PLANNING STATEMENT

37 The Ridings, East Preston, West Sussex, BN16 2TW

This Planning Statement has been prepared in support of application EO/146/18/HH, as the LA do not feel they are able to support the application, as per the following comments;

Project number	37THE-18	A102 REVA
Date	3rd December 2018	
Drawn by	JG	Scale 1 : 100
Checked by	Checker

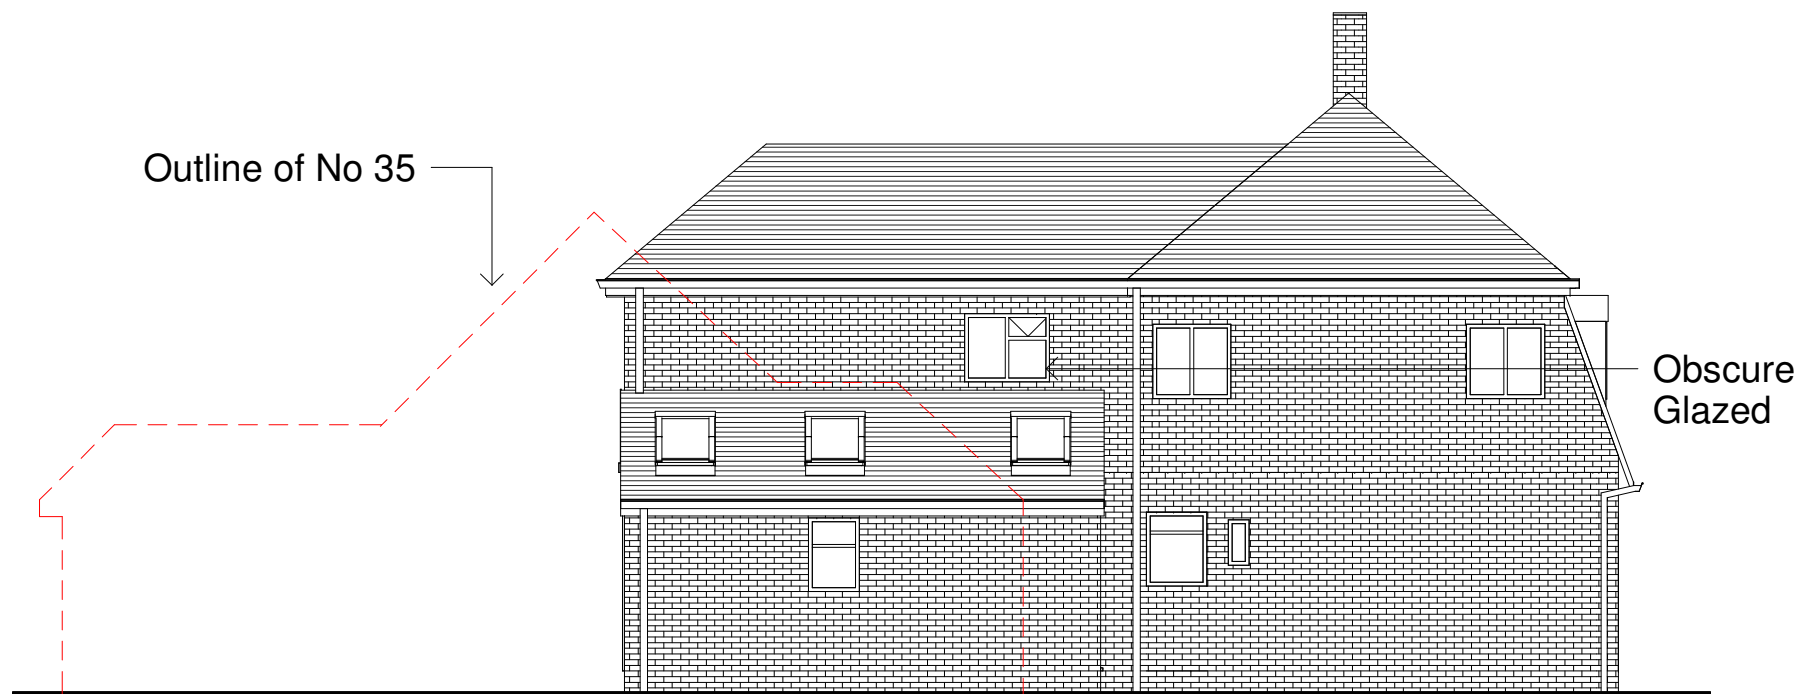
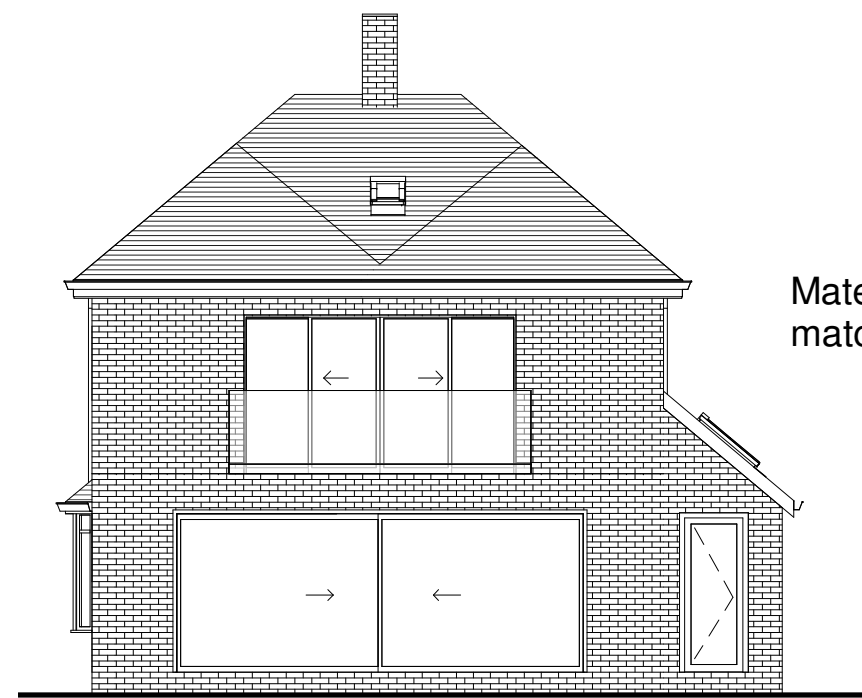
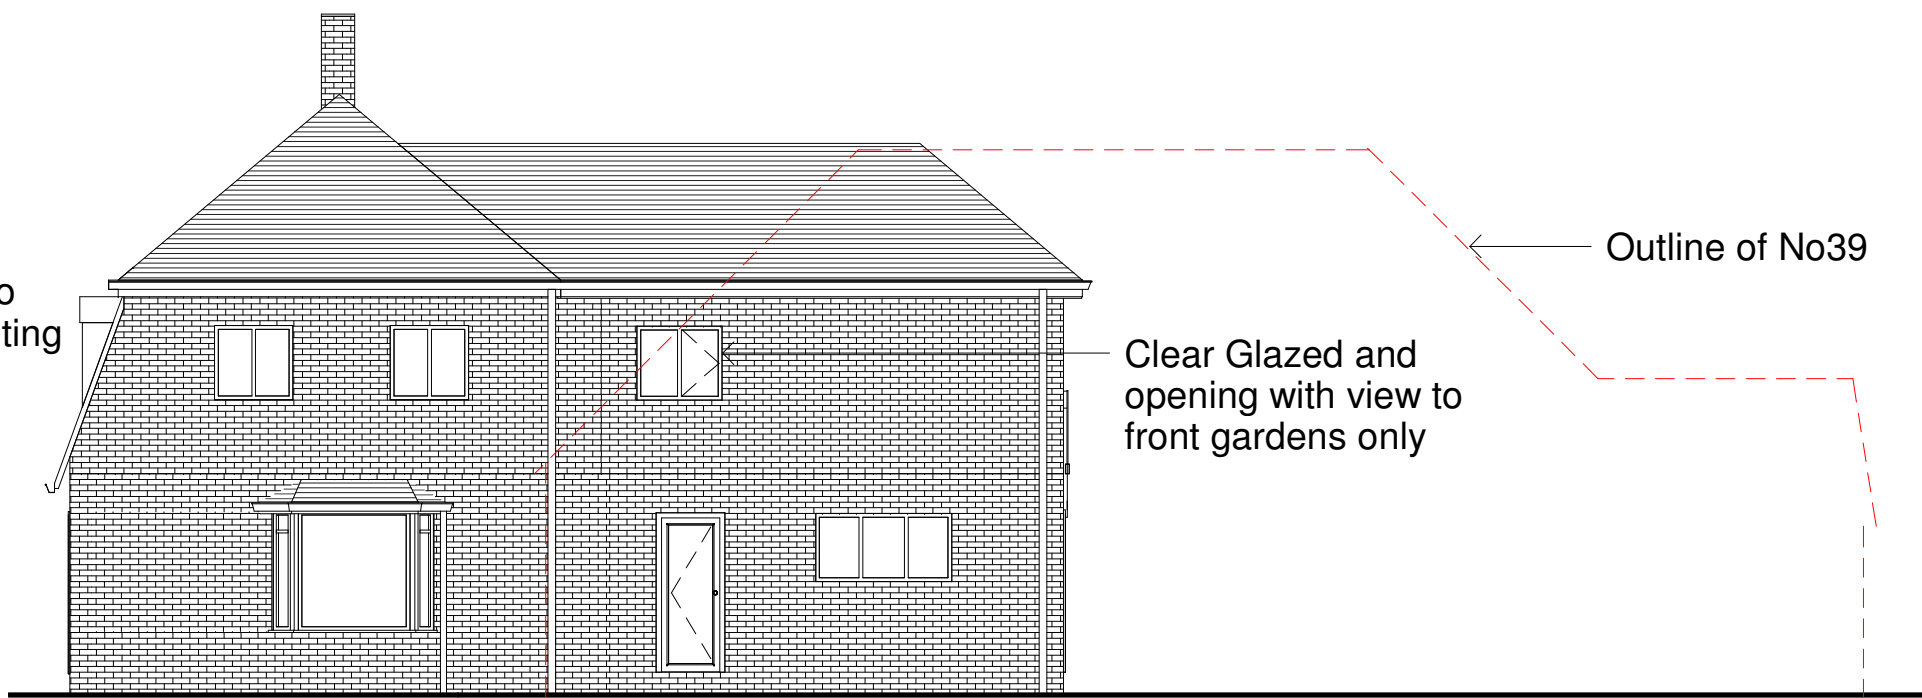
I believe that it is likely that I will be recommending refusal for this application, resultant of its scale, design, massing and proximity to the boundary

On the next page are two clips from the revised drawing sheet A102 which shows an outline of the adjoining neighbour's number 35 & 39 in Red dash lines.

The Red dash line shows that No 37 sits completely in front of No 35. The extension is mainly to the side of No 35, the windows to habitable rooms and the private garden of No 35 would not be affected by the proposed extension. It is only the single storey extension that is approx. 0.990 metres away from the boundary between the properties, the first floor would be over 2.5 metres away from the boundary. No 35 is approx. 0.950 metres away from the boundary

The Red dash line shows that No 37 sits in front of No 39. Again, the proposed extension sits mainly to the side of No 39 and does not affect the windows of habitable rooms or the private garden of No 39. The proposed extension is to be approx. 1.580 metres away from the boundary and No 39 is set over 2.5 metres away from the boundary other than its single garage which is located along the boundary.
